From: Sue Howell <Sue.Howell@arun.gov.uk>
Sent: 14 June 2021 16:54
To: Planning.Responses <Planning.Responses@arun.gov.uk>
Cc: jasmine.kaursingh@arun.gov
Subject: RE: Planning Consultation on: AB/48/21/PL

Application ref: AB/48/21/PL

Description: Construction of 1 No. three bedroom dwelling & associated works. This site is in CIL Zone 2 & is CIL Liable as new dwelling.

Location: Land adjacent to Woods Way House 3 Torton Hill Road Arundel BN18 9HF

Site/Block Plan

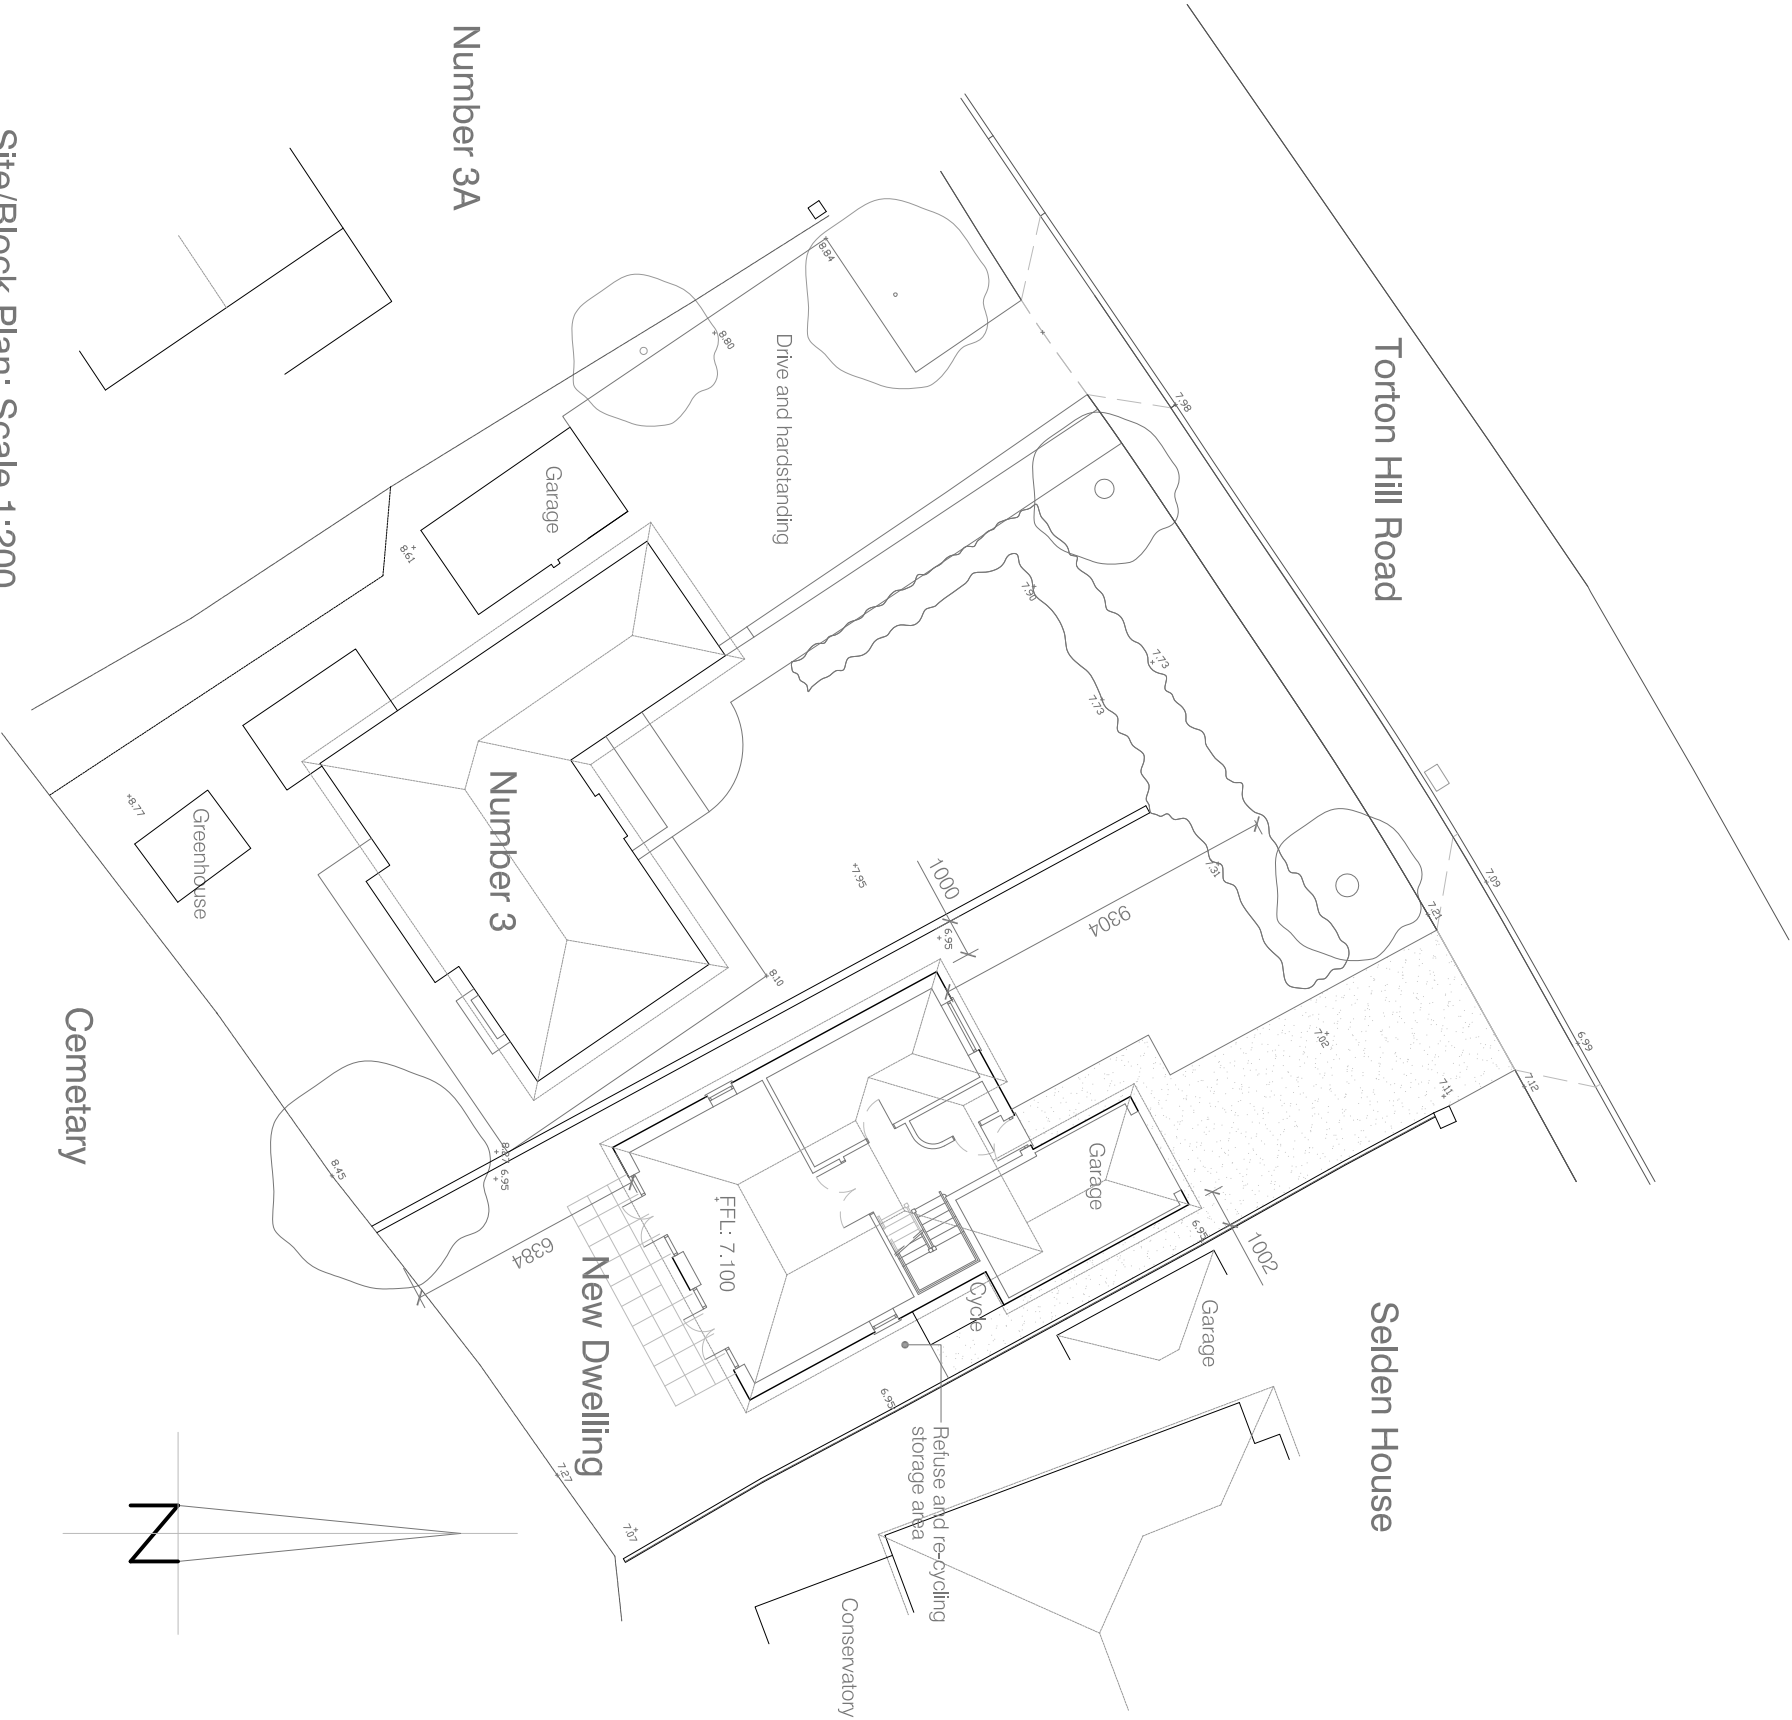
The NPPF para 124/127 relate to good design principles which equally apply to small infill and replacement development. The indicative site layouts would also need to include tree protection plans alongside tree retention and protection details. Some conflict may be evident from the layout with root protection zones in the vicinity of the shown driveway. Any considered tree impact must be in consultation with the LPA Tree Officer.

Landscape provision to the dwelling and improvement with native species infill plus further boundary screening as required. These details would require expanding in the form of a detailed planting plan and specification detailing species choice, actual plant quantities, planting densities and size at time of planting. Detail should also be provided regarding existing trees and boundary planting.

I would recommend no landscape objection to the proposals subject to submission of landscape details to provide ornamental and native improvements and biodiversity gain. To confirm tree protection methods in relation within and beyond the site boundary that may be affected by the development proposals.
